CITY OF ALBUQUERQUE

June 20, 2022

**Re: NEW OFFICE/WAREHOUSE
541 Airport Drive NW
Traffic Circulation Layout
Architect's Stamp None (K10-D023)**

4 ACCESSIBLE PARKING
1/8"=1'-0"

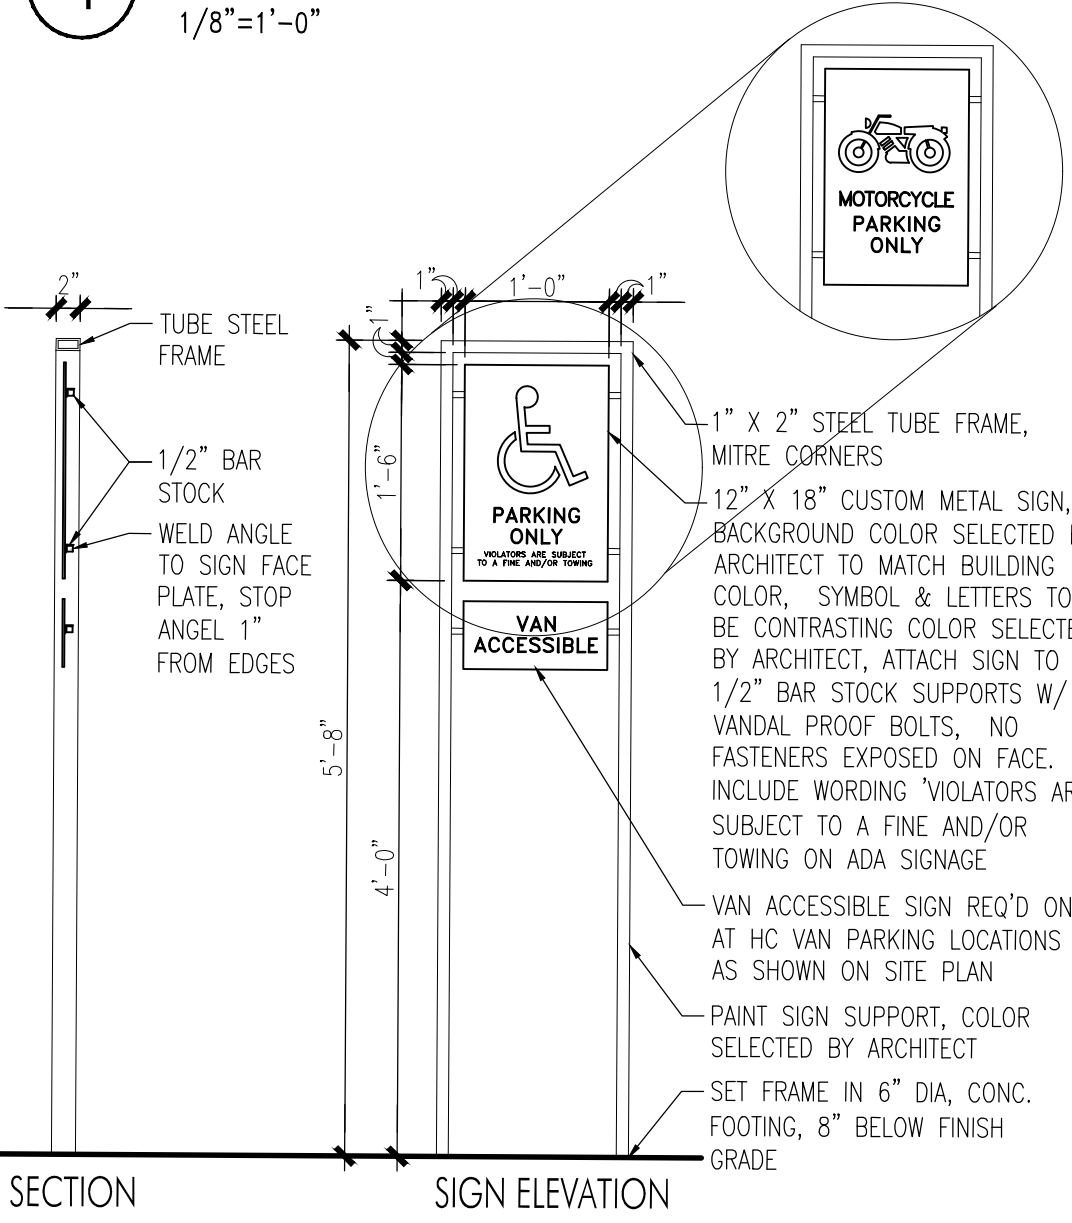
9. **Detail 4 (Accessible Parking):**
 - **The landing will need to be label 50:1 max in all directions.**

- **NO PARKING:** Detail for the text will need to be provided.

DRAWING NAME
SITE DEVELOPMENT
PLAN
PHASE ONE

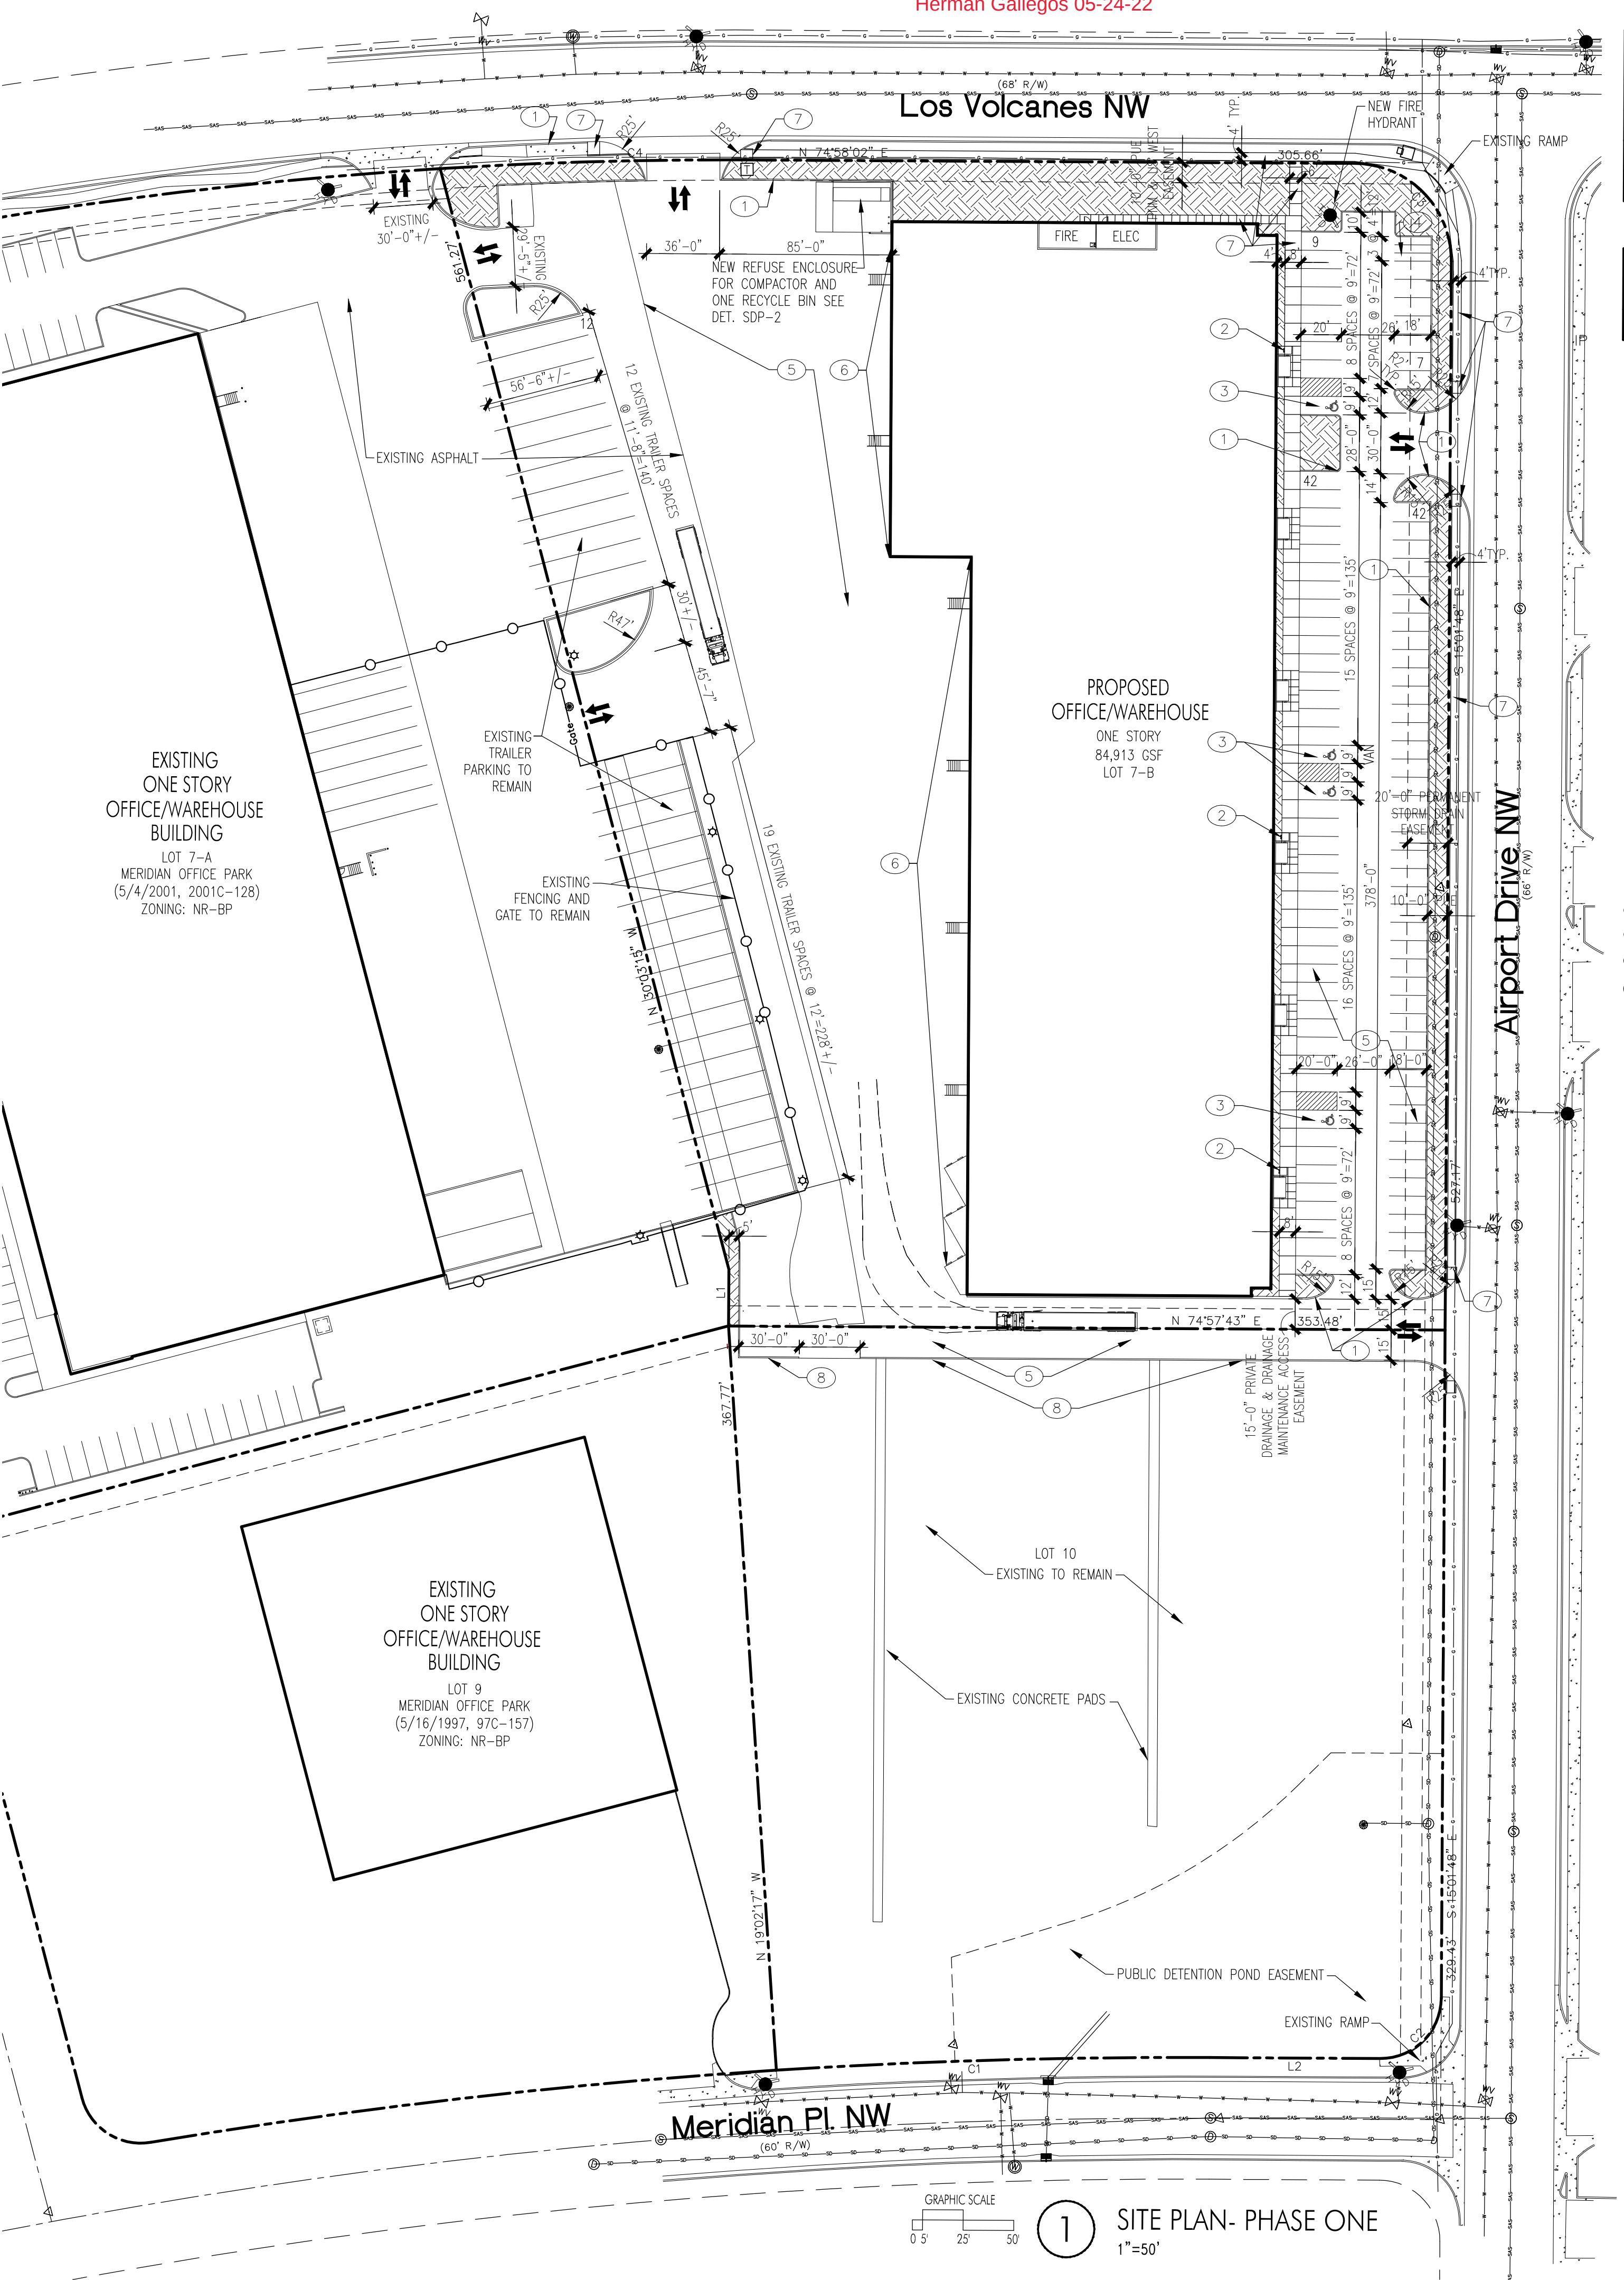
1. Listed are the number of parking spaces required by the IDO as well as the proposed number of parking spaces including bicycle and motorcycle parking.
Coordinate/discuss with Zoning.

3. The traffic circulation layout must be stamped, signed, and dated by an engineer or architect licensed in the state of New Mexico.
4. **Proposed Driveway (Los Volcanes):** Provide entrance design or reference design per COA std dwg 2426.

5. **Airport Driveway:**
 - **First proposed drive entrance location:** What is the distance from Los Volcanes? Verify you meet the required distance from a Collector on Airport.

- **Second proposed driveway:** How will you provide a 6 ft valley gutter across the 30 ft driveway when you are only providing temp. extruded curb and status of ramp on the southside of entrance.

6. **Keyed Note 1:** Please reference detail and sheet number.
7. **Keyed Note 7:**
 - Please provide entrance ramp detail since a detail has not been provided.

- Sidewalk detail will be needed and reference COA std dwg 2430 (public sidewalk) on both Los Volcanes and Airport Drive (when applicable).
8. **Keyed Note 8:** Need to provide detail.

10. Please identify all **proposed buildings, doors, structures, sidewalks**, curbs, drive pads, wall and anything that influences the parking and circulation on the site.
11. Identify all existing access easements and rights of way width dimensions.
12. Identify the right of way width, medians, curb cuts, and street widths on Los Volcanes and Airport Drive.
13. **The minimum parking stall dimensions are:**

14. The ADA accessible parking sign must have the required language per 66-7-352.4C NMSA 1978 **"Violators Are Subject to a Fine and/or Towing."** Please call out detail and location of signs. The sign height is not correct. **Please review COA standards for correct signage height.**

15. The ADA access aisles shall have the words **"NO PARKING"** in capital letters, each of which shall be at least one foot high and at least two inches wide, placed at the rear of the parking space so as to be close to where an adjacent vehicle's rear tire would be placed. (66-1-4.1.B NMSA 1978). **Provide details.**

16. All ADA curb ramps within public ROW must be updated to current standards and have truncated domes installed. Please verify corner of Los Volcanes/Airport ramp complies with these requirements stated.

18. **Motorcycle parking spaces:** Label pavement MC. Provide detail for pavement text.

22. Bicycle parking spaces shall be at least 6 feet long and 2 feet wide.
 23. Per DPM, a 6 ft. wide ADA accessible pedestrian pathway is required from the ADA parking stall access aisles to the building entrances. Please clearly show this pathway and provide details. **Adjacent to bicycle parking there is a bump out and no dimension provided, so this segment of sidewalk will needed 6ft width without the bump and overhang from vehicle parking stall as well as the second & third set of ADA parking stalls. Throughout the parking lot there shall be a clear 6ft pedestrian pathway, this will need to be shown on the site plan with sidewalk widths.**

30. Please provide a sight distance exhibit
 31. **Intersection Sight Distance:** A clear sight line will be needed on Airport and Los Volcanes intersection for turning movements for Airport Drive.

DATE MAY 2022
NORTH SCALE
1"=50'-0"
OR AS NOTED
DRAWING NAME
SITE DEVELOPMENT
PLAN
PHASE TWO
SHEET NUMBER

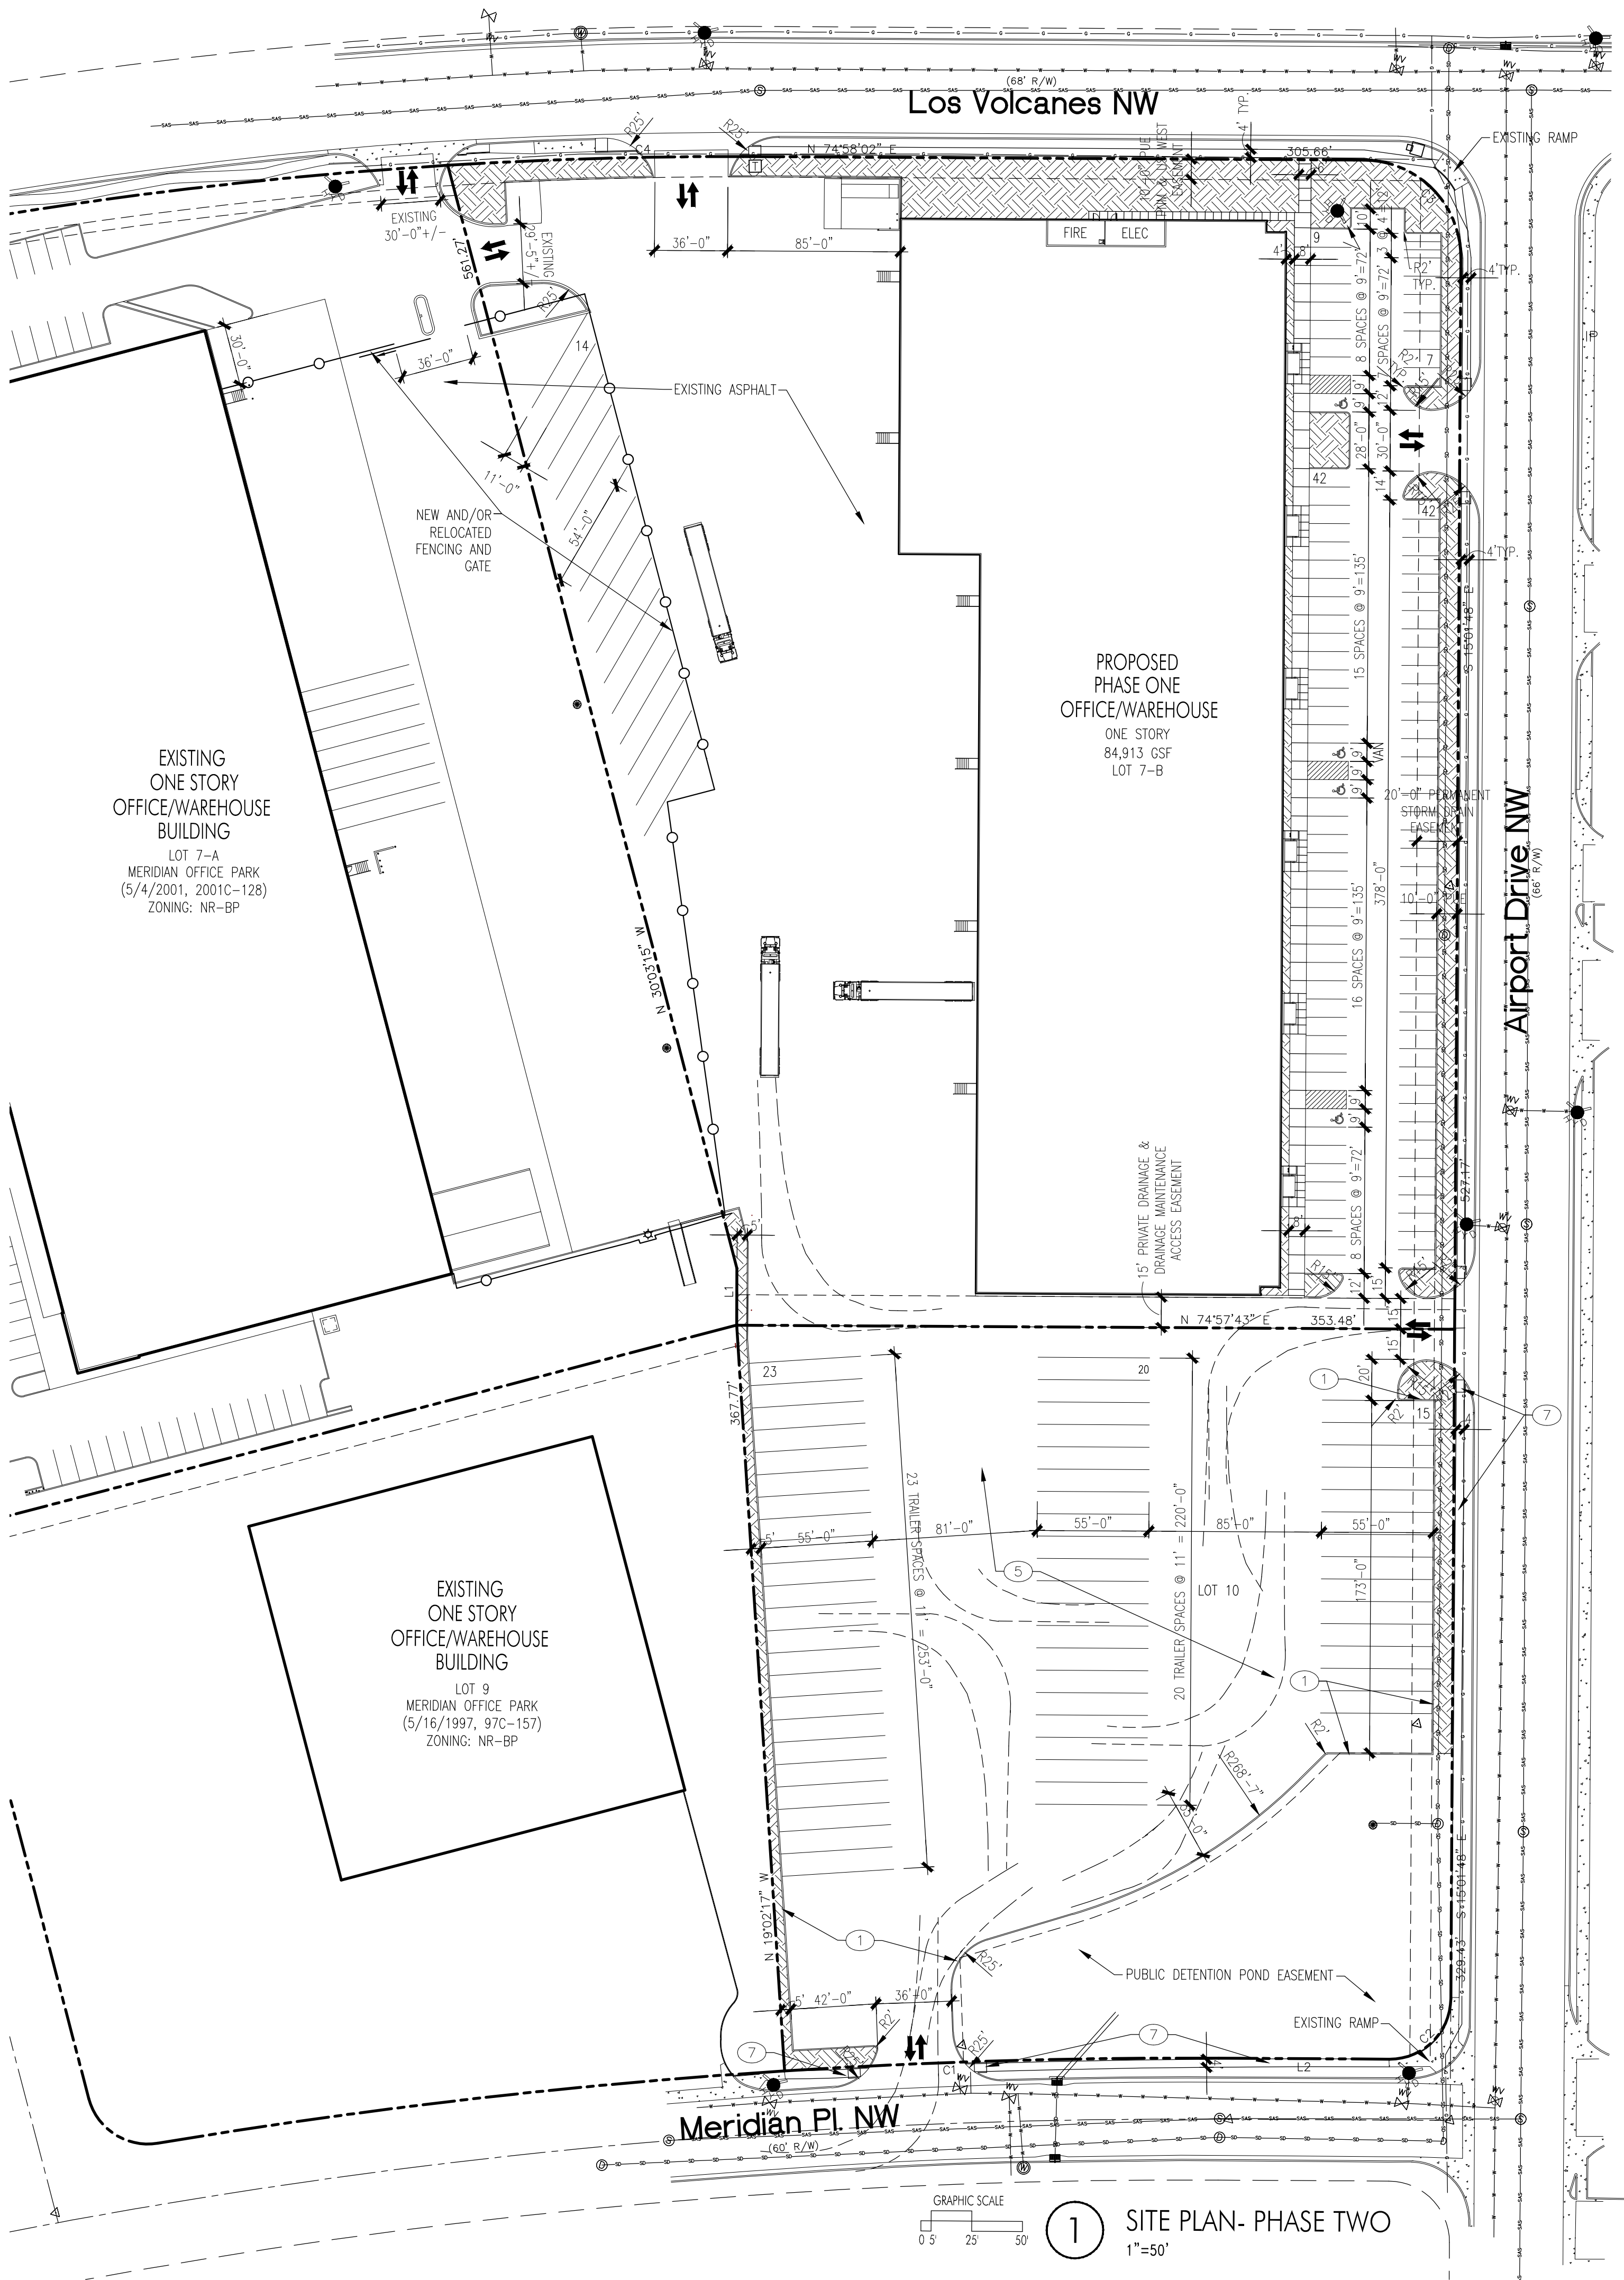
2. Clarify the extents of the current phase 1 versus phase 2. Are you proposing phase 2 as part of this submittal ? Explain since phase 2 is on a different lot and will required a separate submittal and fees. I will not comment on sheet SDP-2 until the appropriate action is taken for the submittal process.
